Outline application with some matters reserved for the erection of up to 160 dwellings with public open space, landscaping and sustainable drainage systems (SuDs), vehicular access point from Arundel Road together with up to 557 square metres of B1/B2 units with associated parking provision & vehicular access point from Arundel Road & land made available for expansion of current sports pitch provision to form a sports-hub (following the demolition of existing commercial units and one bungalow) (resubmission following A/36/18/OUT). This application is a Departure from the Development Plan.

Land off Arundel Road Angmering

Thank you for your internet representation made on 2nd October 2019 which has been recorded as '**an objection**' with the comments as follows:

Figure 5.2: Illustrative Masterplan.

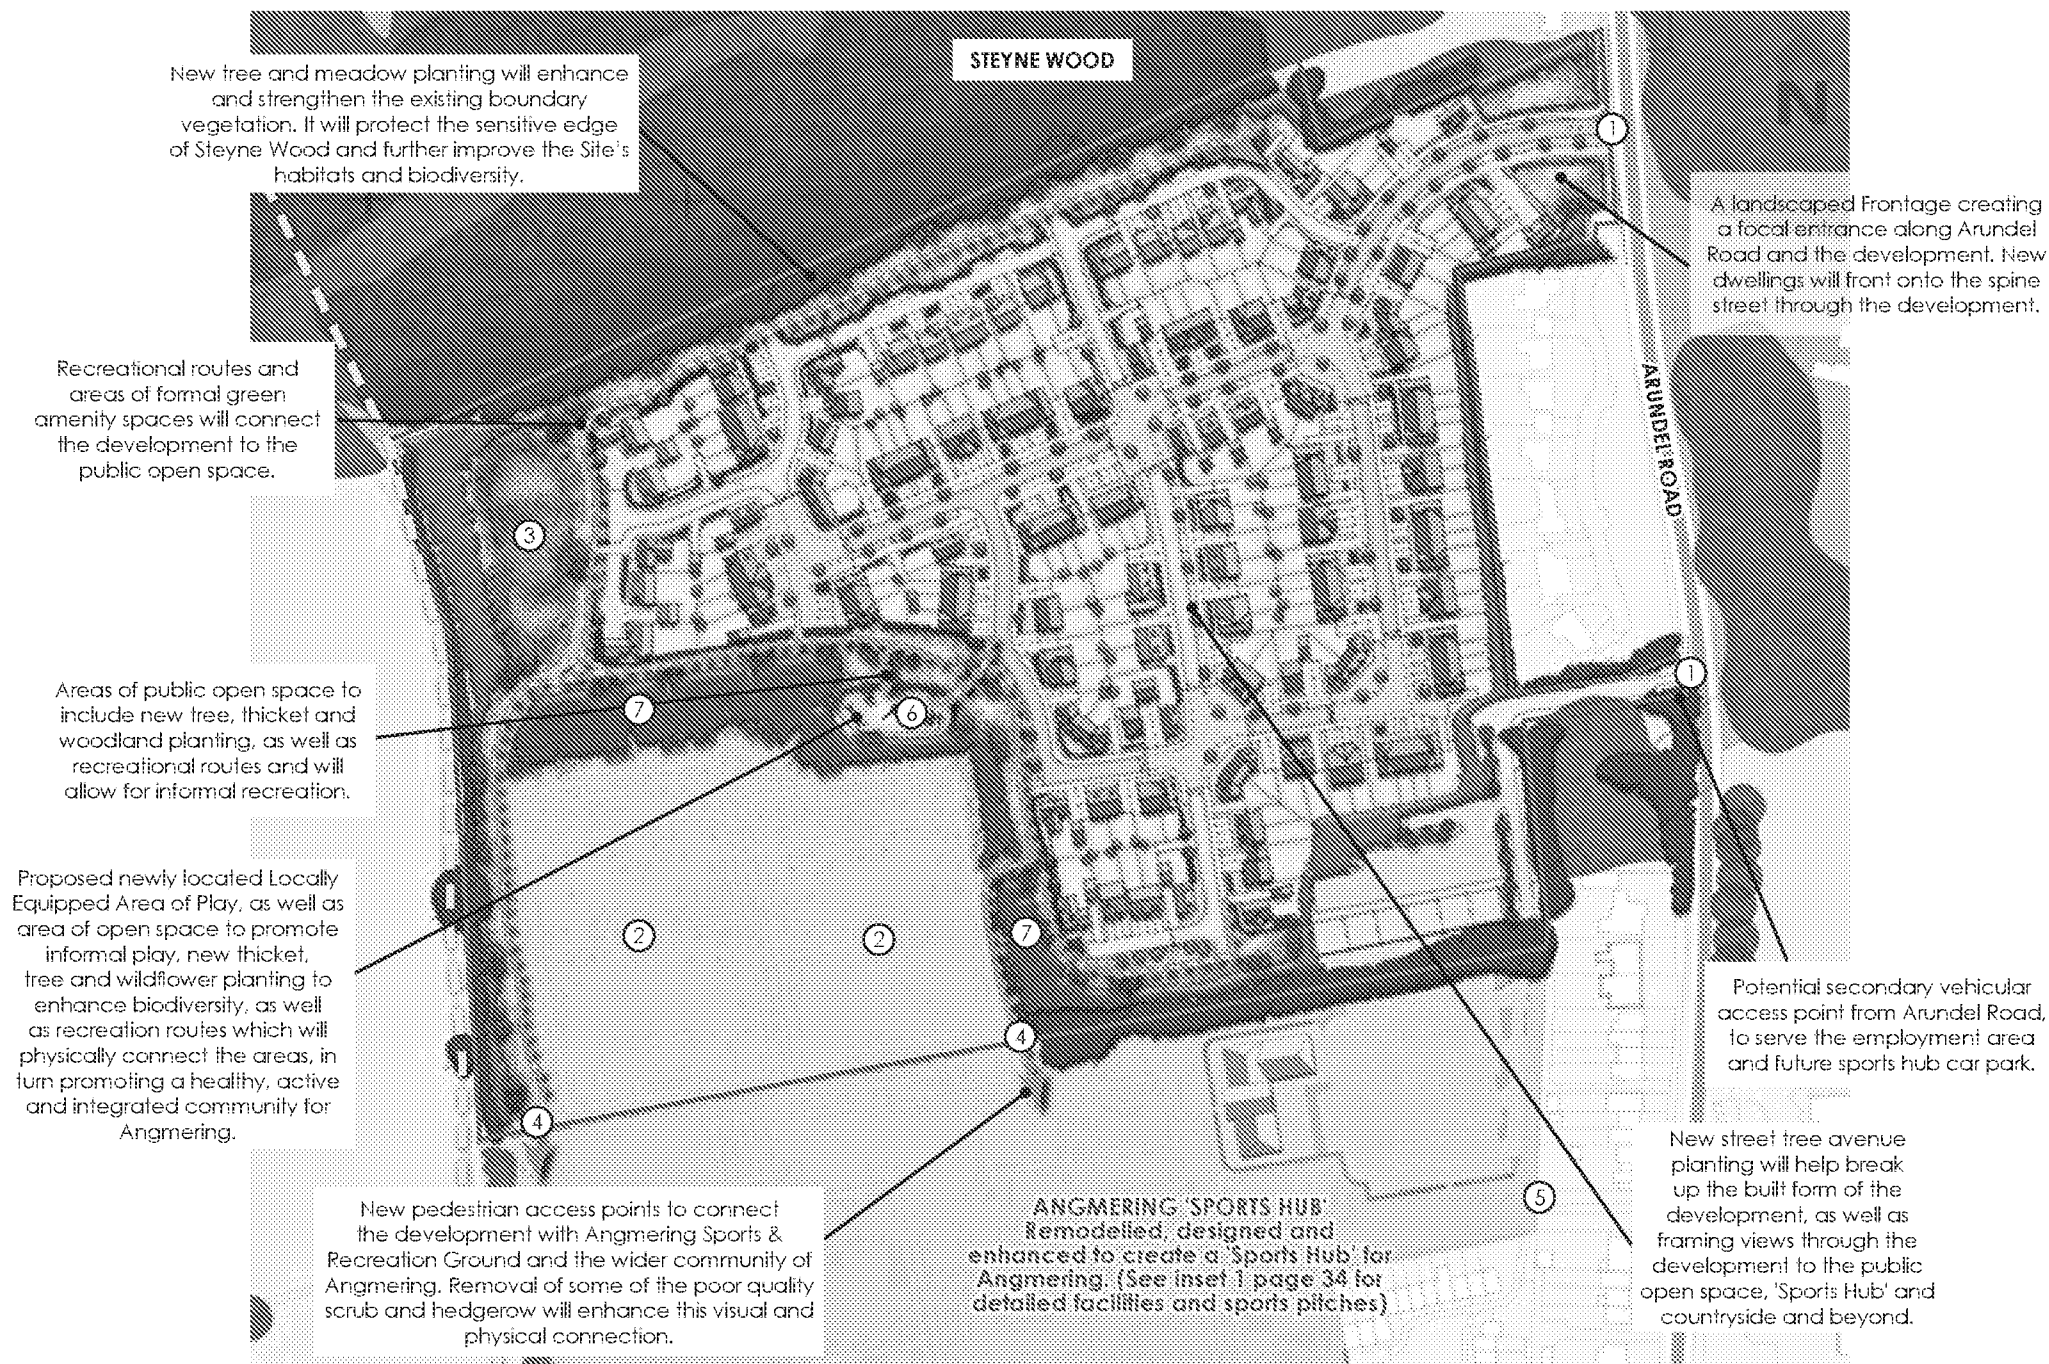
The industrial and commercial units are far too close to existing housing. Although they replace a caravan storage yard which can be argued is already commercial, the current use creates no noise or disruption to residents. The same will not be assured by the new development so cannot be placed in such a way as to disturb existing residents. If there has to be a commercial aspect then place it on the far boundary, well away from existing residents. If it borders on new residential properties then at least people have the choice whether to live next to them or not. Or would this detract from potential sales revenue.....??

There is a proposed community/sports pavilion very close to existing residents. This will no doubt be a source of noise if functions are held there. This should be moved to a more suitable location or removed.

There is a proposed secondary street leading to 150 parking spaces and this has been routed adjacent to existing residential properties creating unacceptable noise and pollution. This must be relocated.

At the rear of our property, 68 Arundel Road, there is no screening or planting shown...presumably this is an incorrect omission and needs to be added regardless of what lies on the other side.
